**RFI**

**RFI #:** 186  
**Date:** 8/24/2012  
**Job:** EB-02 Keller Springs Lofts  
**Phone:** 877-777-5115

**Subject:** request to change route of exhaust and dryer duct

**Drawing:** M1.1  
**Cost Impact:** None

**TOP LEVEL EXHAUST FAN DUCTING DETAIL**  
SCHEMATIC - NO SCALE

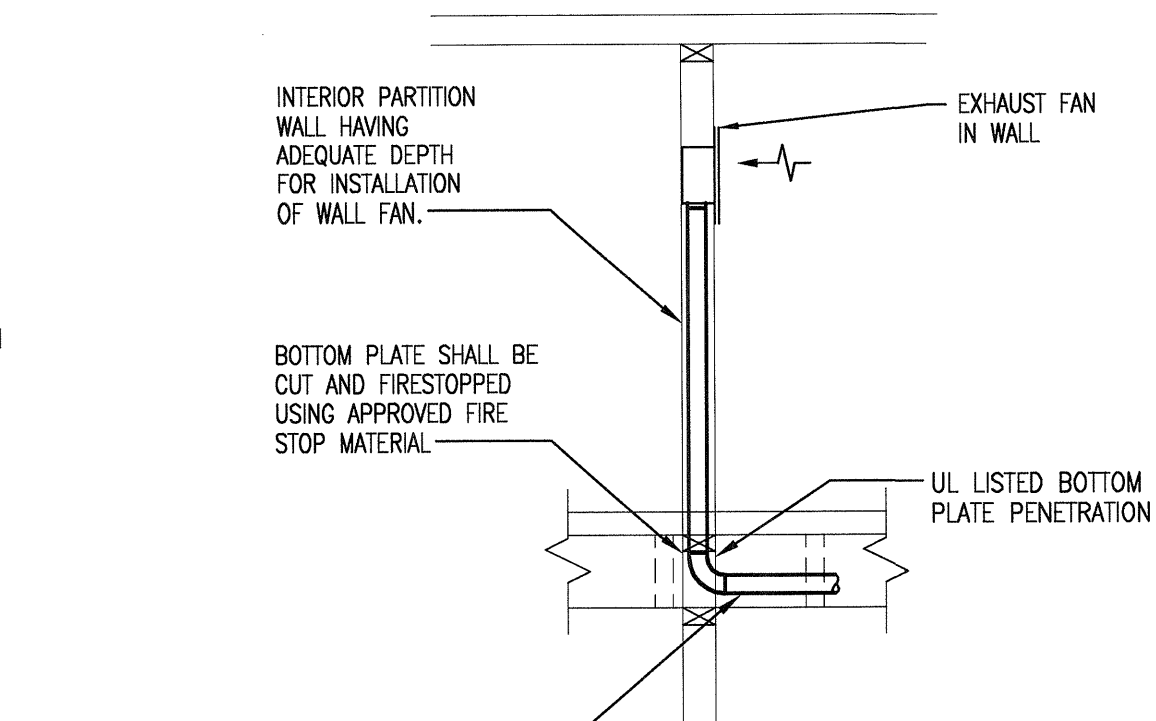
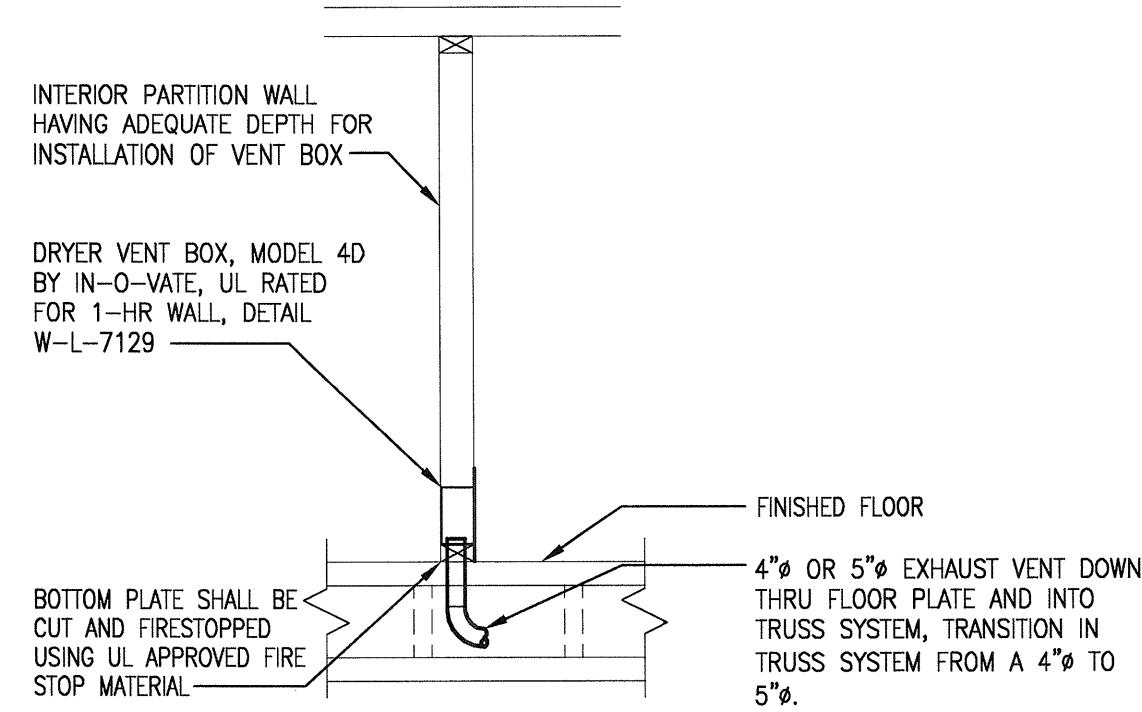
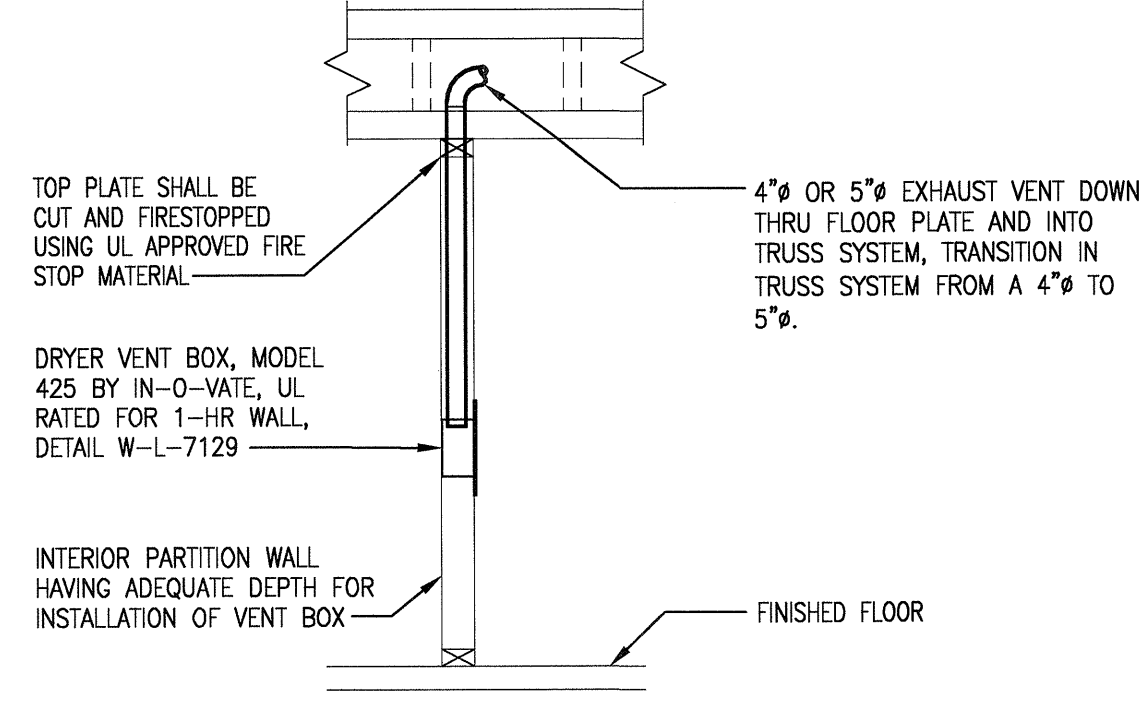
**Request:** **Date Required:** 8/27/2012  
M-1.1 shows the top level exhaust fan detail and the top level dryer ducting detail to go down into the 3rd floor ceiling. Since we have a flat roof here we would like to run both of these through the 4th floor ceiling. The units with stackable washer and dryers make going down on the 4th floor extremely difficult with the dryer vent being located above the washer box. Need an answer ASAP for the crews to come back next week and start the rough in on the 4th floor.

**Response:**  
JSE: seal roof penetrations weather tight. Architect must also approve.  
BGO: penetrating 4th floor ceiling is acceptable. Penetrating the roof is not acceptable. Make sure no stucco banding is penetrated. Coordinate so all units are the same.
